Our Case Number: ABP-314942-22

Re: BusConnects Lucan to City Centre Core Bus Corridor Scheme
Lucan to Dublin City Centre

BUSCONNECTS
SUBMISSION OF OBSERVATIONS
PALMERSTOWN BYPASS

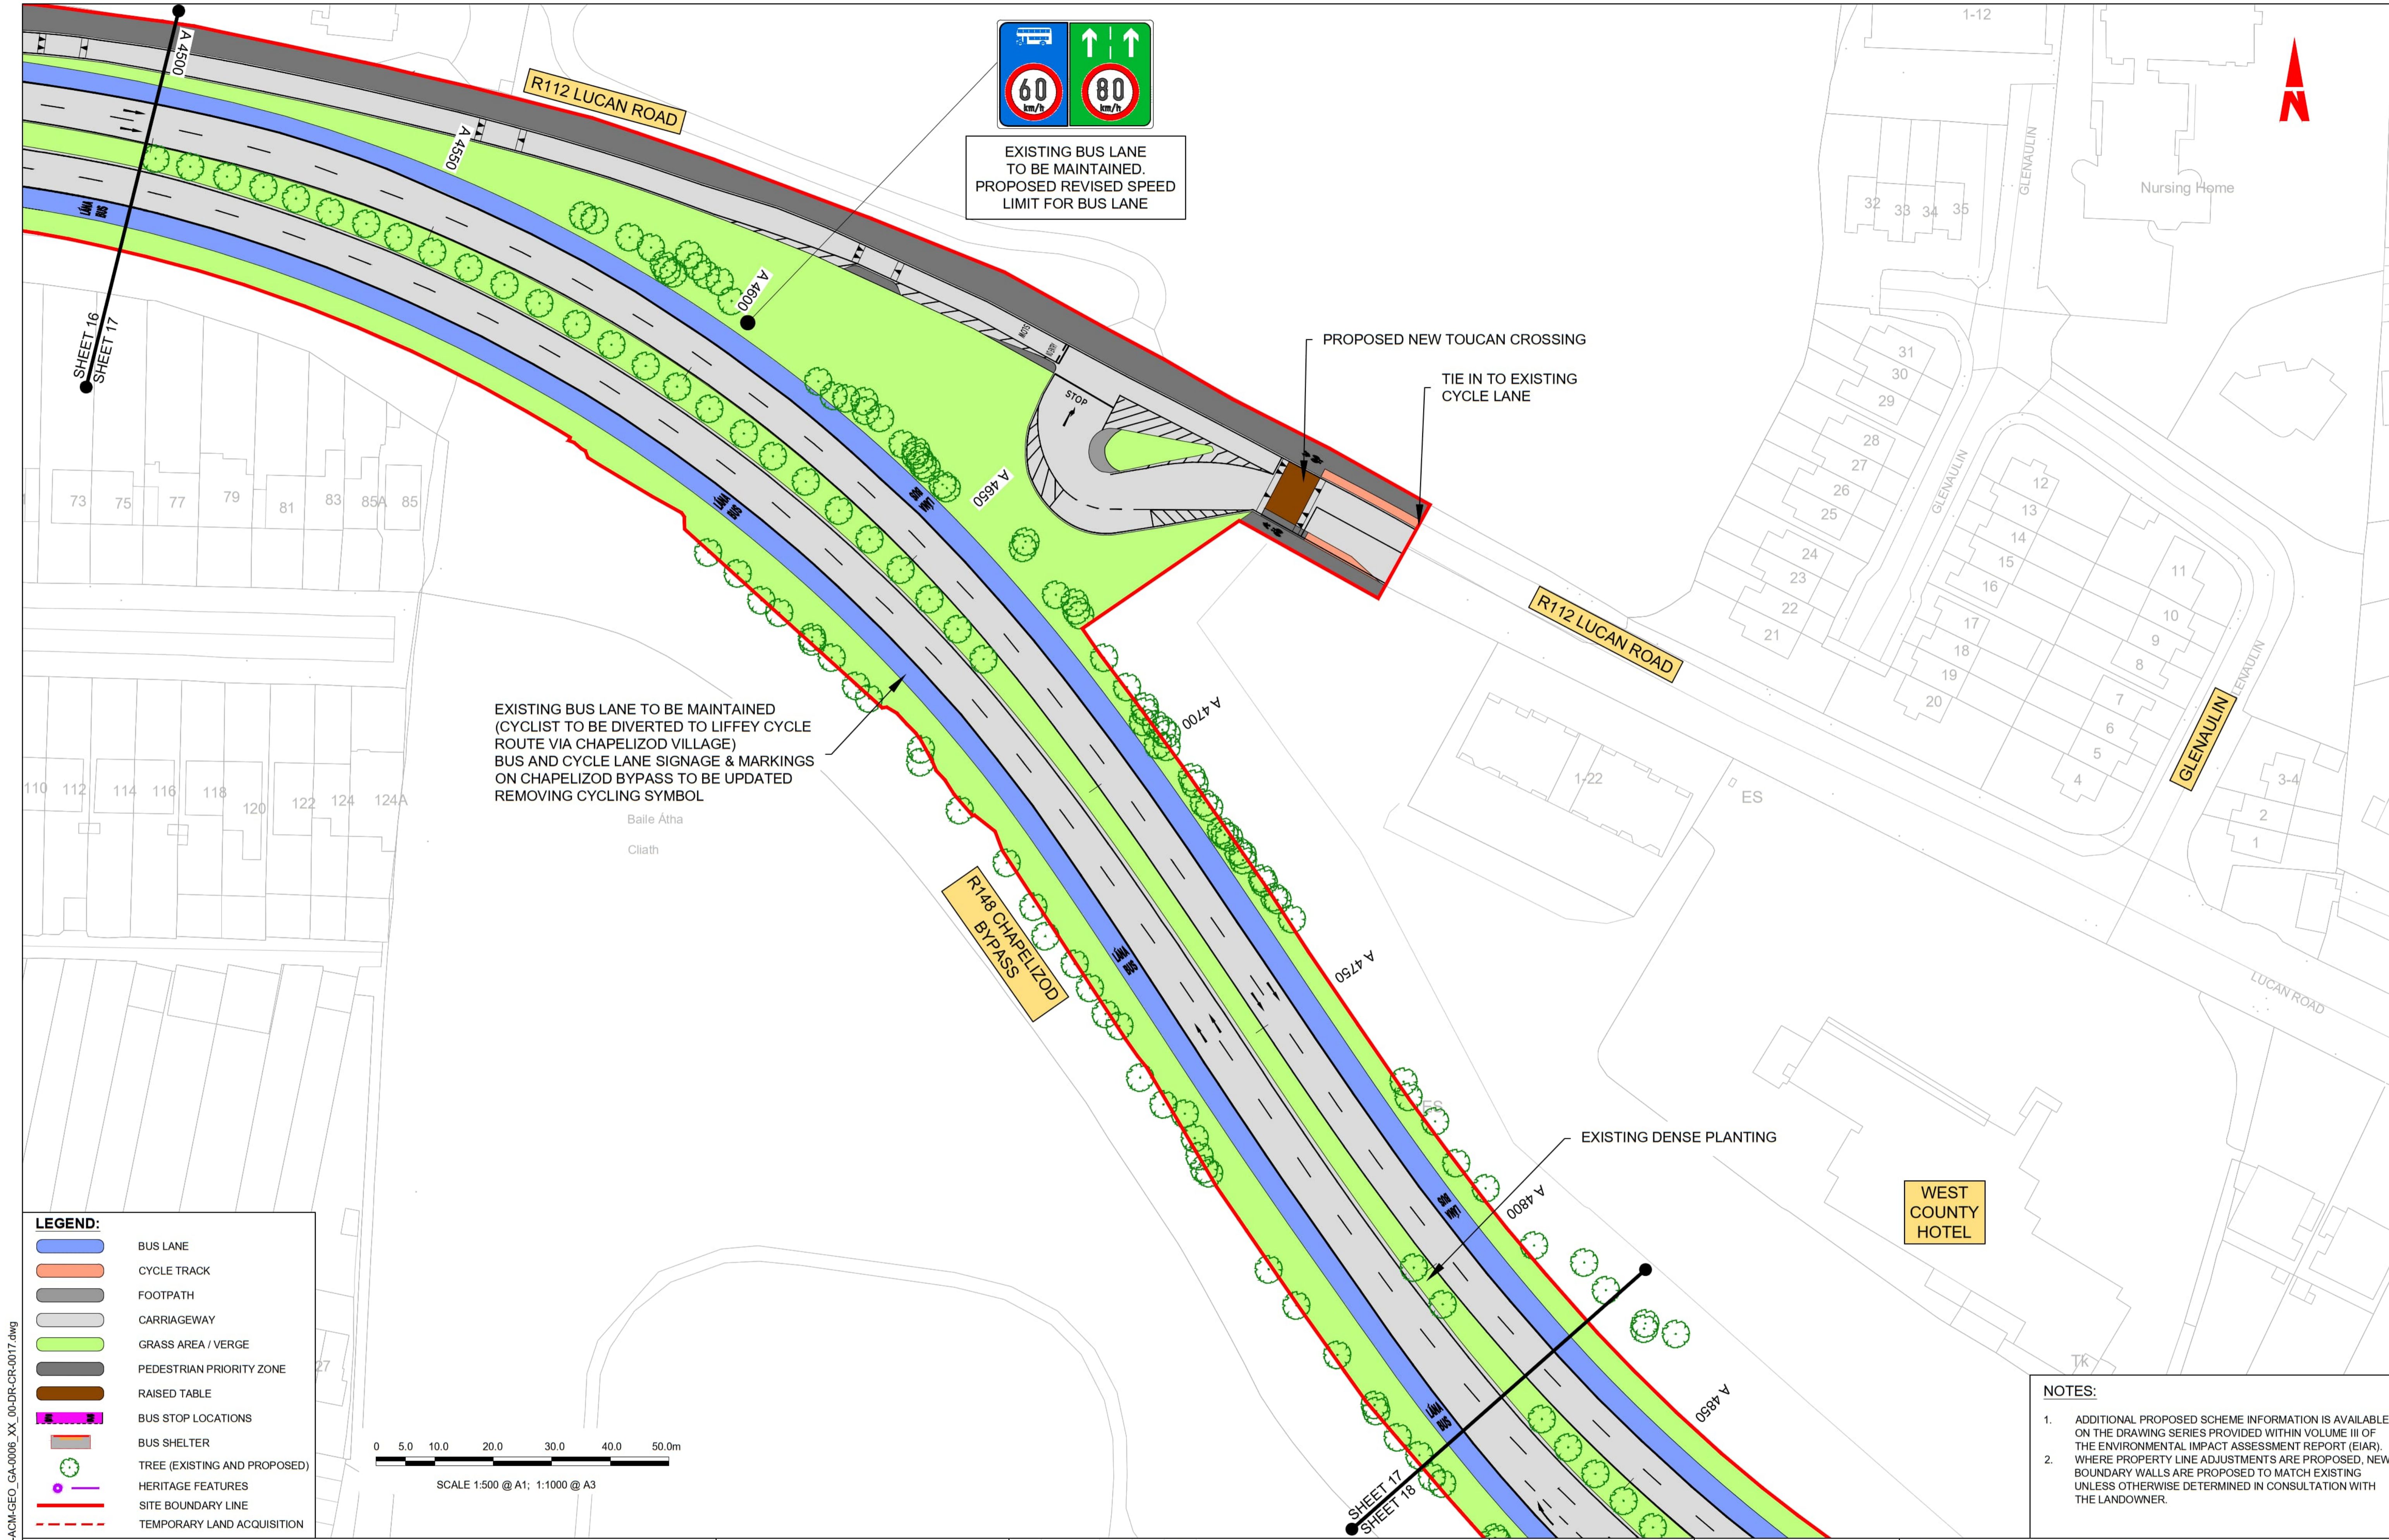
We have examined the proposed changes to the Transport System as applied to the Palmerstown Area – Drawings No. 17 and 18.

The plan to have the new No. 80 Bus route turn into the old Palmerstown Village serves no useful purpose whatsoever and would create many knock-on problems and dangers. This is something that nobody asked for and that nobody wants, we presume therefore that it must be an NTA decision.

We assume that the removal of the bus stop at Palmerstown Drive is to facilitate the No. 80 Bus crossing over from the left lane to the right lane. This would be a mammoth task to ask any bus driver to perform most especially on a dark wet evening when the traffic is bumper to bumper which is regularly the case. It would be difficult to avoid an accident and all the chaos that this would cause.

Also, all the other buses that stop at Palmerstown Drive, travelling out of town, would no longer be able to do so causing great hardship to a lot of people including ourselves as we use this bus stop on a regular basis.

The removal of the facility that allows cars etc to move into the bus lane about fifty metres before the turn left into the housing estate at The Oval is a very dangerous proposal.

The NRA have not removed the right to turn left but have made it very awkward most especially as they also propose narrowing the access by widening the path which would only add to the difficulty of the turn. For instance, there are shops in the housing estate that have goods delivered by truck regularly. Instead of turning left from the bus lane one is now expected to cross the bus lane. This very dangerous manoeuvre would be something akin to Russian roulette!

There are two Primary Schools located at The Oval. At the moment the level of traffic exiting The Oval at school opening and closing times is very heavy indeed and can back up as far as Culmore Road leading to long delays. We shudder to think what the traffic hold-ups would be like with the removal of the slip lane and widening of the footpath. This would make life more difficult than it already is traffic wise for all who may be exiting this area at these times. In these circumstances and when a driver's patience is tried, accidents can happen.
